DRB Application No.: <u>06DRB-00222 (SBP)</u>	Project # <u>1004709</u>
Project Name: <u>JOURNAL CENTER, UNIT 2</u>	
Agent: <u>John Klee Architecture</u>	Phone No: <u>602-323-7441</u>

**3. Project # 1004709**  
06DRB-00222 Major-SiteDev Plan BldPermit

JOHN KLEE ARCHITECTURE agent(s) for THREE AM, LLC request(s) the above action(s) for all or a portion of Lot(s) 2, Phase 2, **JOURNAL CENTER, UNIT 2**, zoned IP, located on WASHINGTON NE, between RUTLEDGE NE and WOLCOTT NE containing approximately 1 acre(s).  
(D-17)

**Project # 1004709**  
06DRB-00222 Major-SiteDev Plan BldPermit

A-3

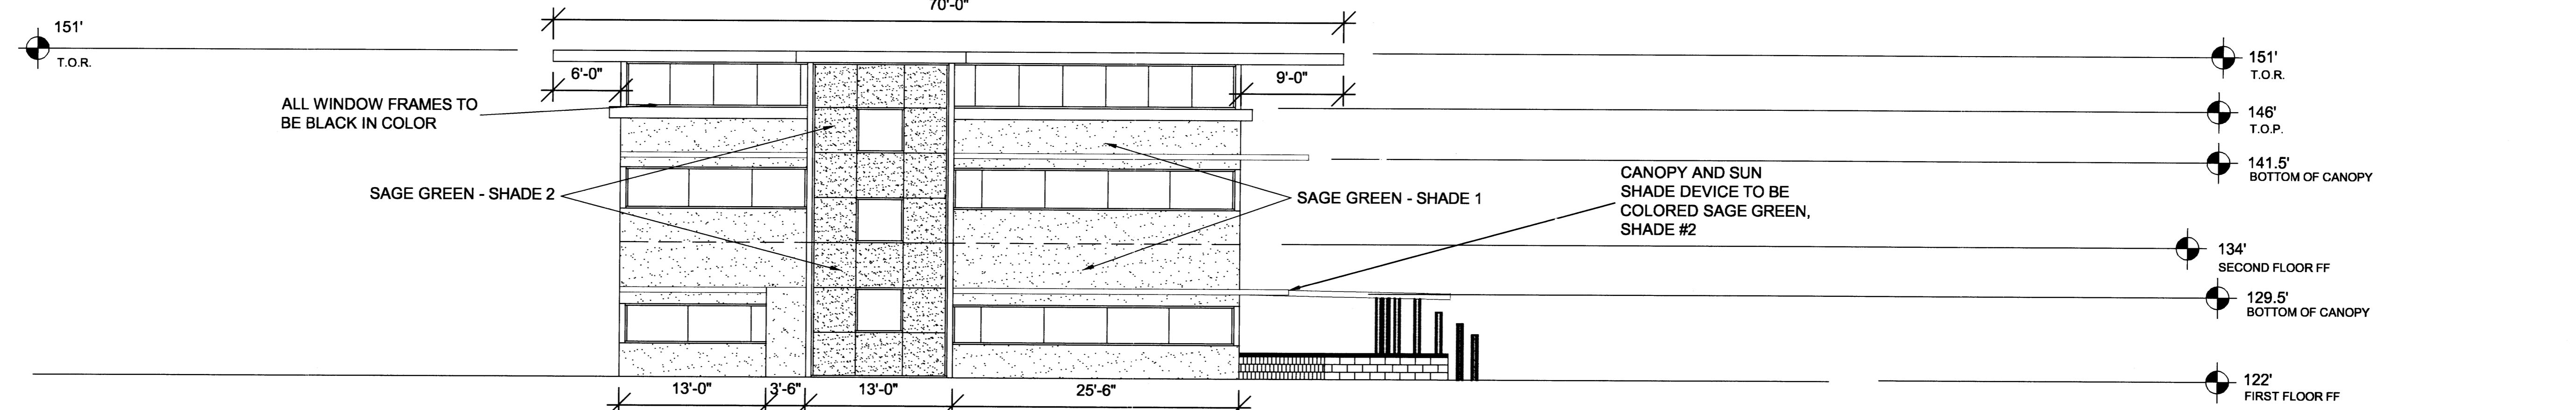
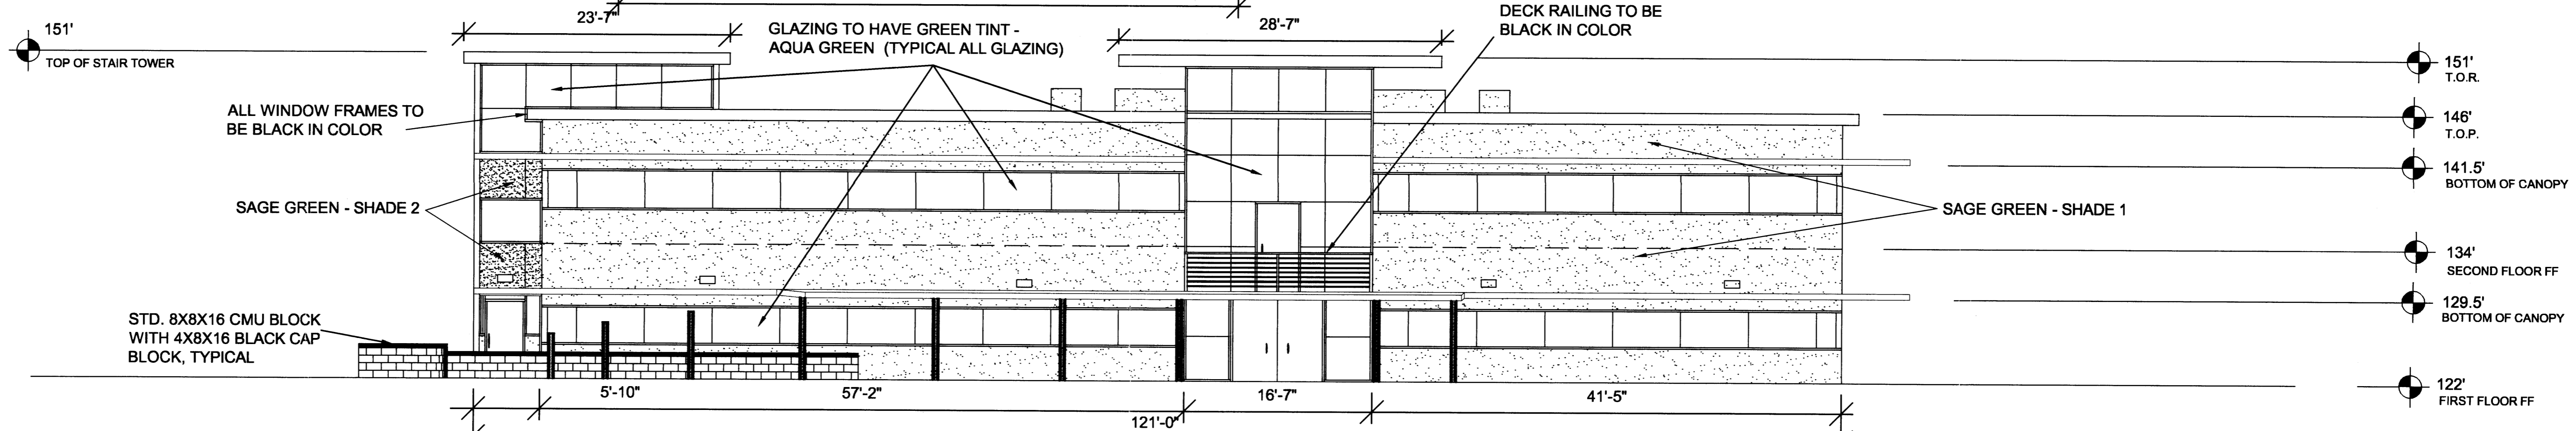
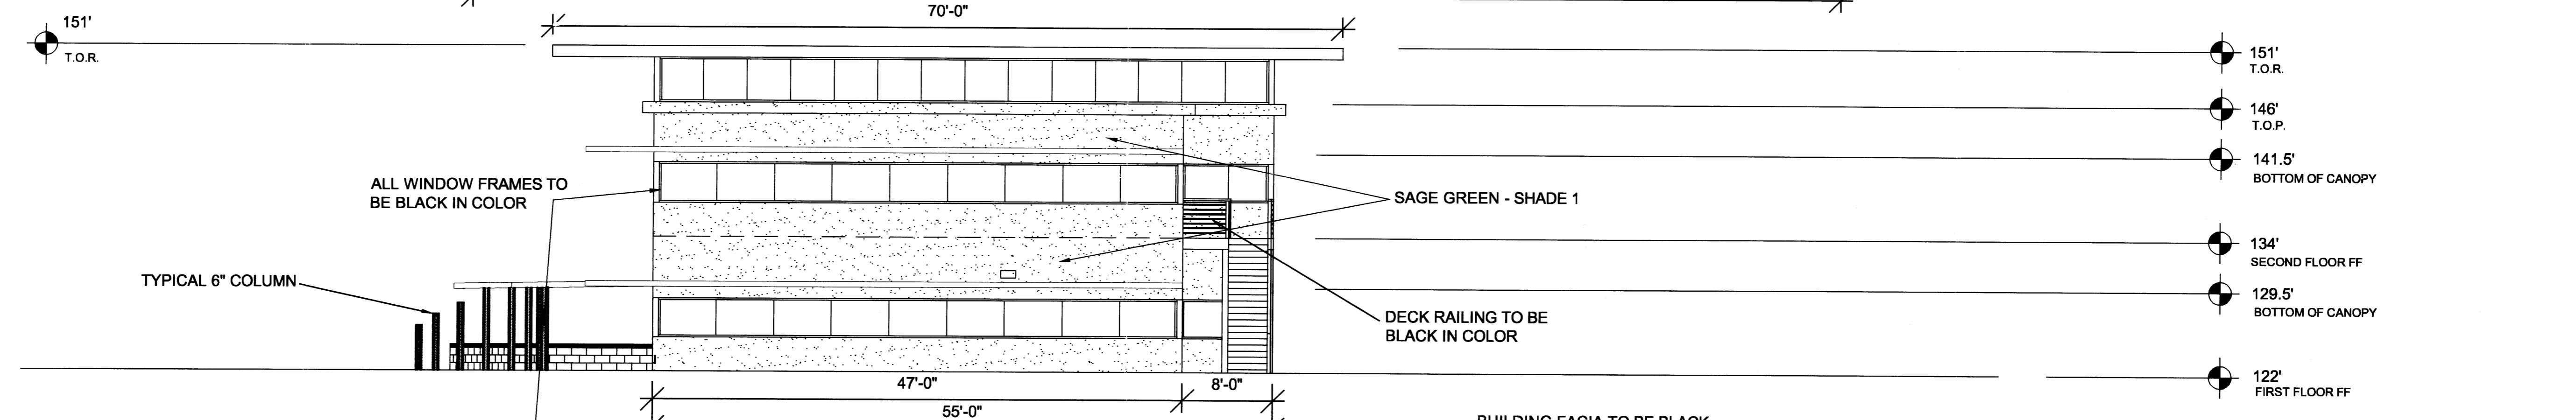
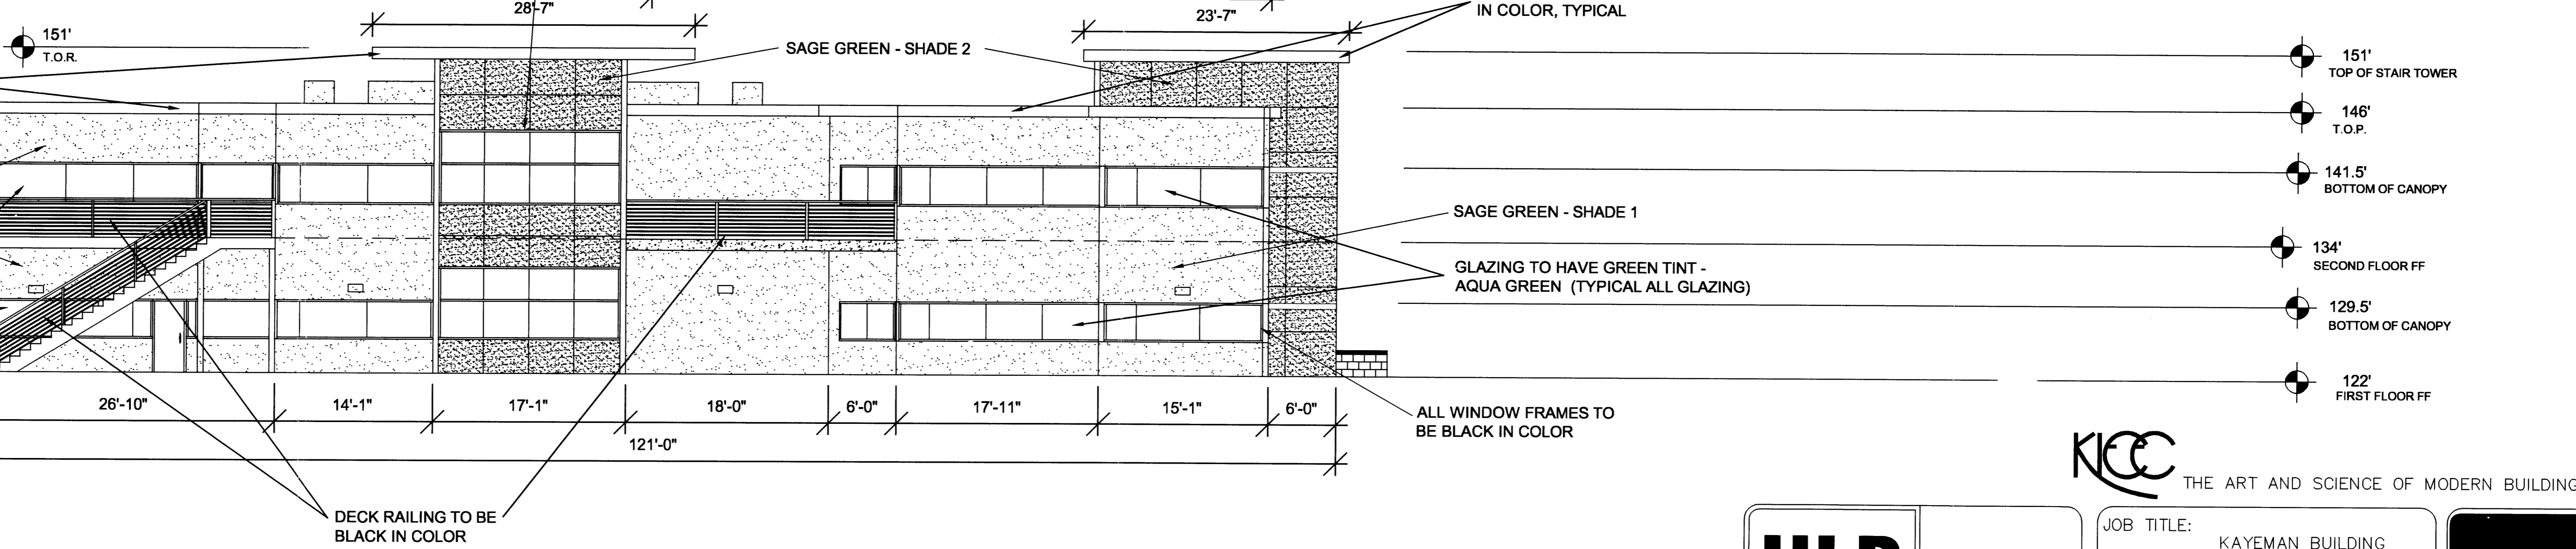
- Planning's remaining comments:
1. A copy of the Journal Center
  2. ARC approval letter is needed before Planning signs SPBP.
  2. Use of the structure: ~~state~~ indicate on the structure on Sheet A1?
  3. The building structure materials are not indicated on sheet A3?
  4. Is the only site lighting building mounted?

✓ 5. The total length of the building is also required on the Elevations sheet (A3).

5. The location, material and colors of windows, doors & framing is missing as are the materials and colors of all building elements & structures.

AMAFCA	No adverse comments.
COG	No adverse comments.
Transit	No objection to the request.
Zoning Enforcement	Elevations exceed the 26 feet allowed.
Neighborhood Coordination	Letter sent to Alameda North Valley NA (R).
APS	The request for a building permit for a new office building in the <b>Journal Center, Unit 2</b> , will have no adverse impacts to the APS district.
Police Department	A review of the following DRB case(s) indicates the following problems or crime may occur or that the following concerns may need to be evaluated or addressed on this site or in this area. These comments do not indicate that a thorough CPTED evaluation has been done, or that other criminal activities may not occur. All pedestrian and vehicular access points should be well illuminated landscaping should be low-level at maturity and should not obstruct view and/or conflict with area lighting. Other: Other types of crime and activity could be impacted depending on the site usage.
